REQUEST

Current Zoning: N1-D (Neighborhood 1-D)
Proposed Zoning: MUDD-O (HDO) (Mixed-Use Development District, Historic District Overlay)

Approximately 3.23 acres located on the northeastern corner of the intersection of West Boulevard and Mint Street.

The petition proposes to redevelop the site of Wilmore School, including adaptive reuse of the existing school building, with up to 250 multi-family and/or single-family attached residential units, 3,500 square feet of retail/EDEE/personal service uses, and 4,300 square feet of office uses.

RZ - 200

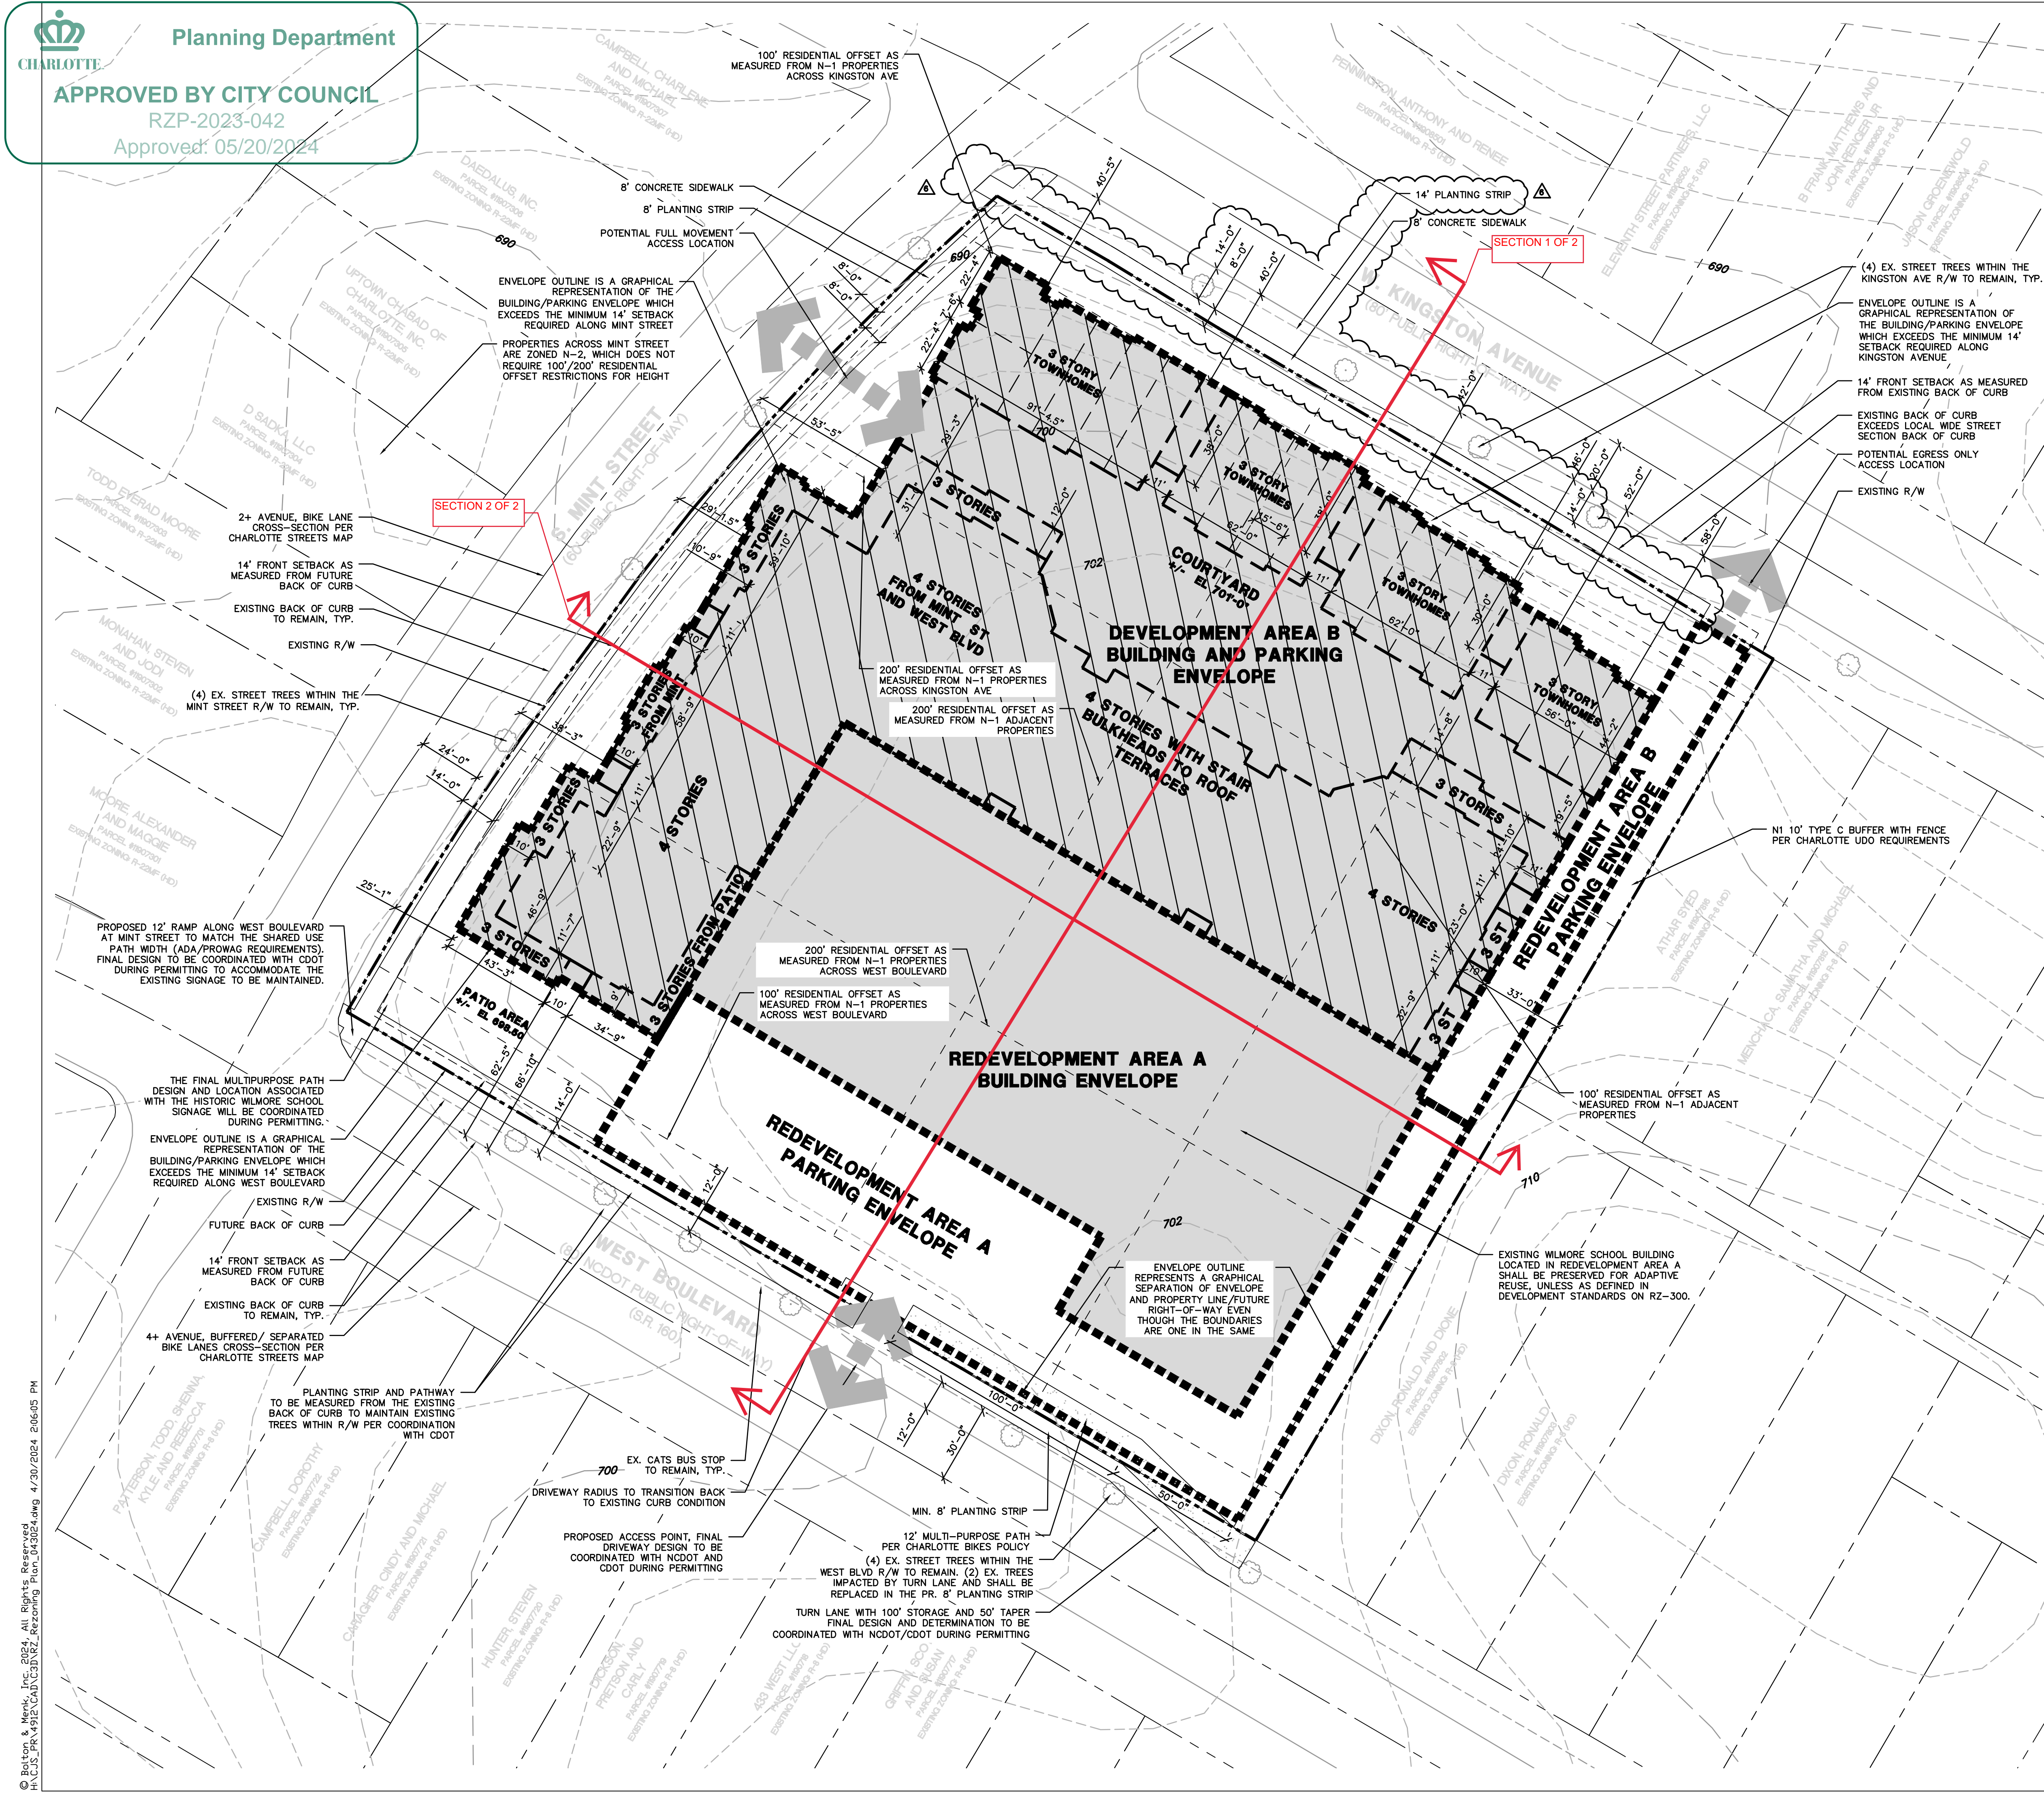
1. Illustrate a proposed 12' ramp along West Boulevard at Mint Street to match the shared use path width (ADA/PROWAG requirement). **ADDRESSED**

5. ~~Revise site plan to show West Kingston Avenue planting strip as 14' to match HDC plan. OUTSTANDING~~
6. ~~Revise South Mint Street cross section to show new building parapet height at 45'3" to match HDC plan. OUTSTANDING~~
